**WEST SUSSEX COUNTY COUNCIL
STRATEGIC PLANNING CONSULTATION**

DATE: 07/12/2017

**SUBJECT: LU-295-17
New Industrial Unit**

Drawing Title: PROPOSED UNIT PLAN

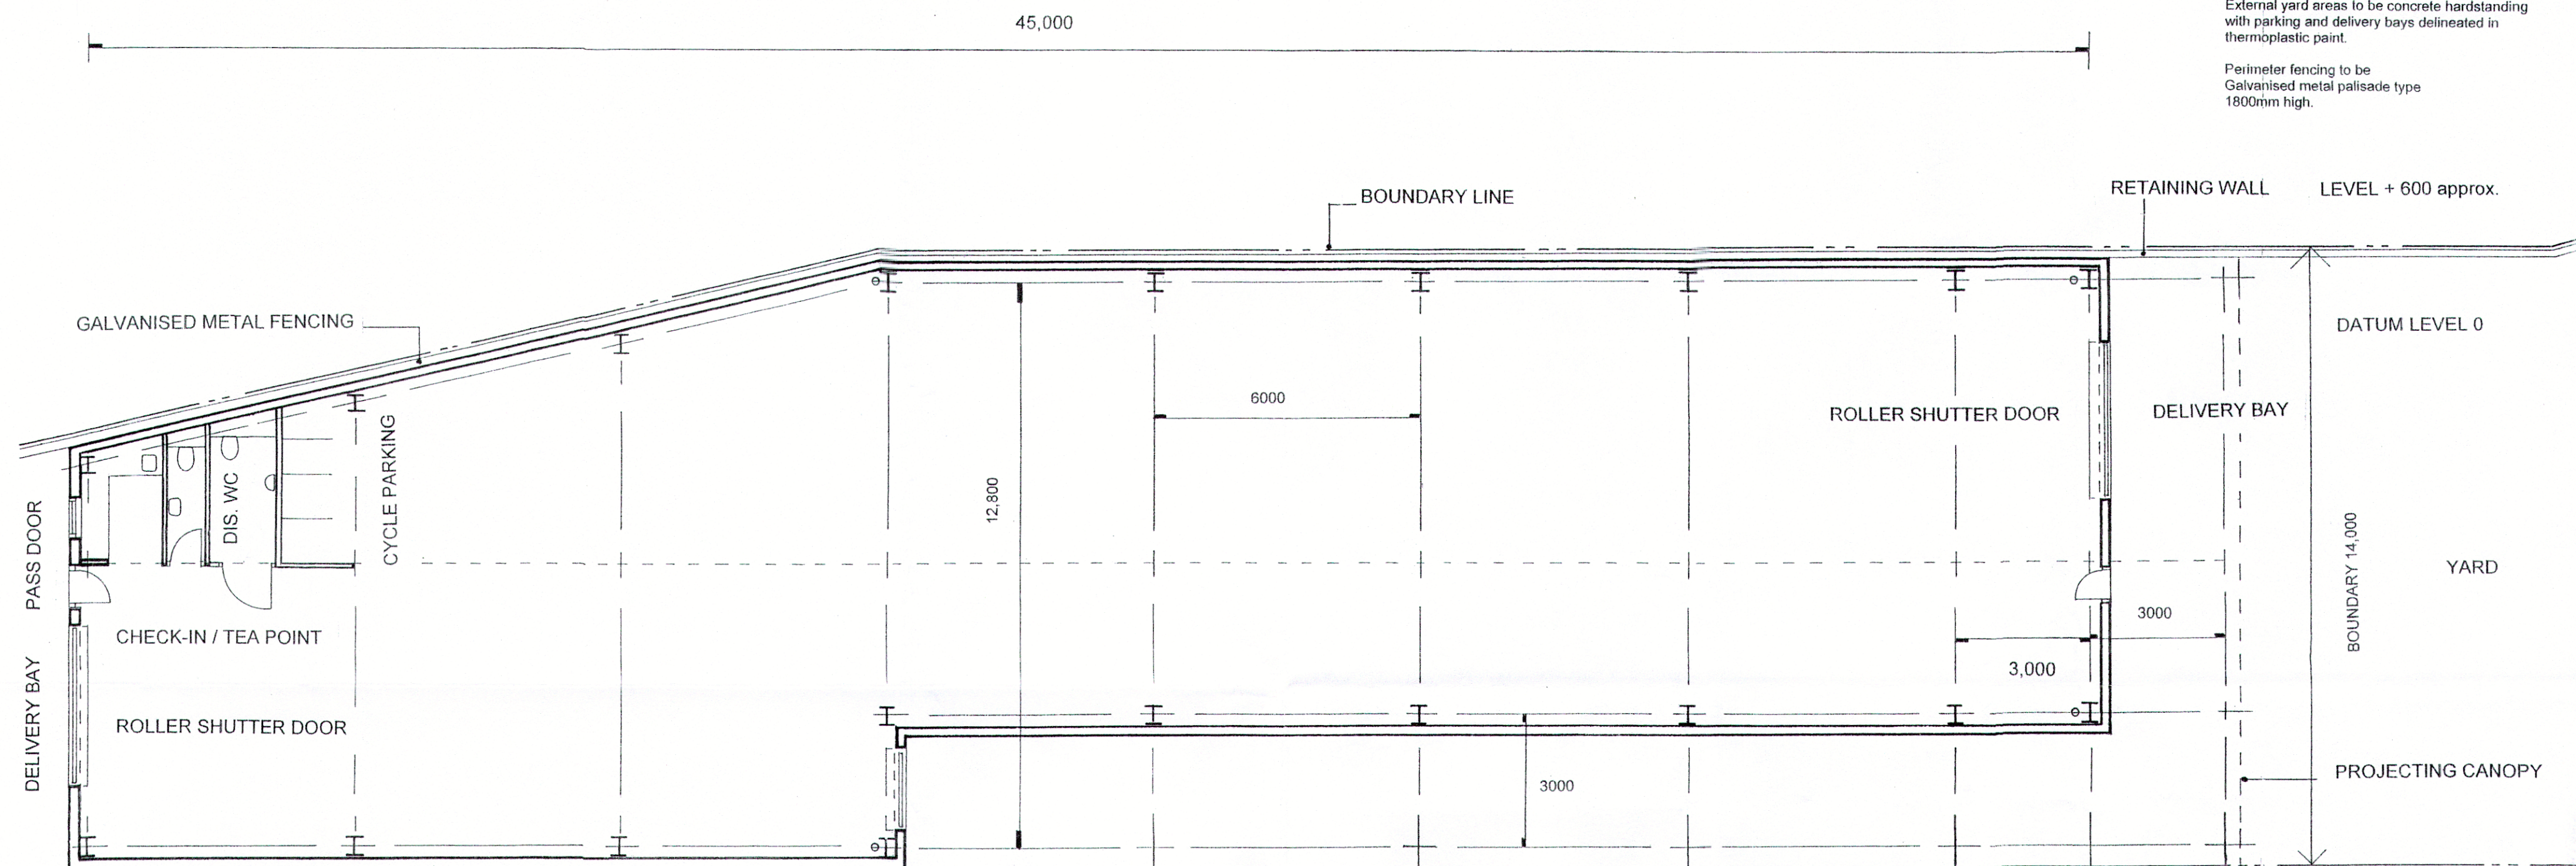
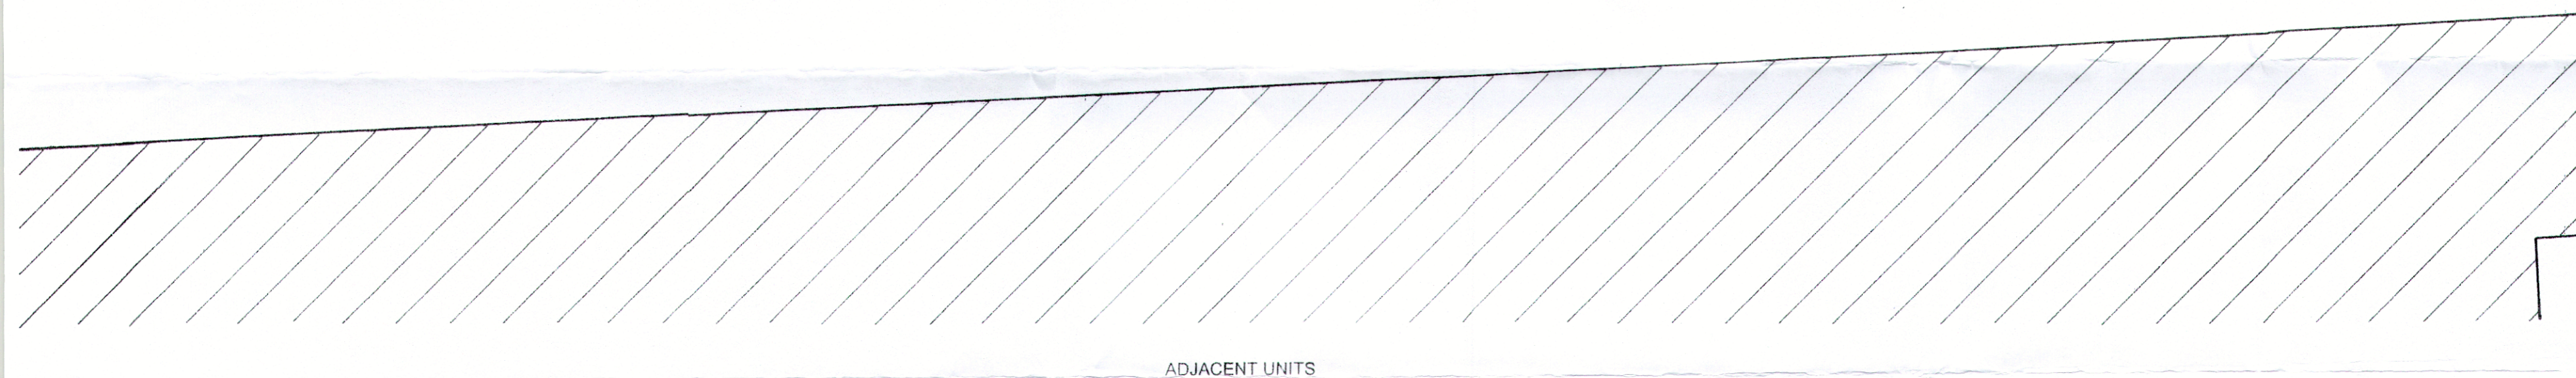
There are expected to be up to 5 lorries and 3 delivery vans per day and plenty of circulation space within the site to accommodate these in order for them to enter and exit in forward gear. The entrance to the site from the public highway is laid out in a one way system helping to keep good circulation of the traffic flow in and out of the site.

Parking is provided for 8 cars plus one space for a disabled driver. WSCC car parking standards for B2 use is 1 space per 40sqm which for a unit of 490sqm would equate to 12spaces. This is a maximum standard, and based on the number of employees (17) it seems reasonable that this number would work if car sharing, or the promotion of sustainable travel either by bike, rail or bus was encouraged. Secure cycle storage is provided on site

It is noticed there is no lorry parking provided on the site; and it is unclear where these lorries and delivery vans would park for loading or unloading.

No part of the development shall be first occupied until covered and secure cycle parking spaces have been provided in accordance with plans and details submitted to and approved by the Local Planning Authority.
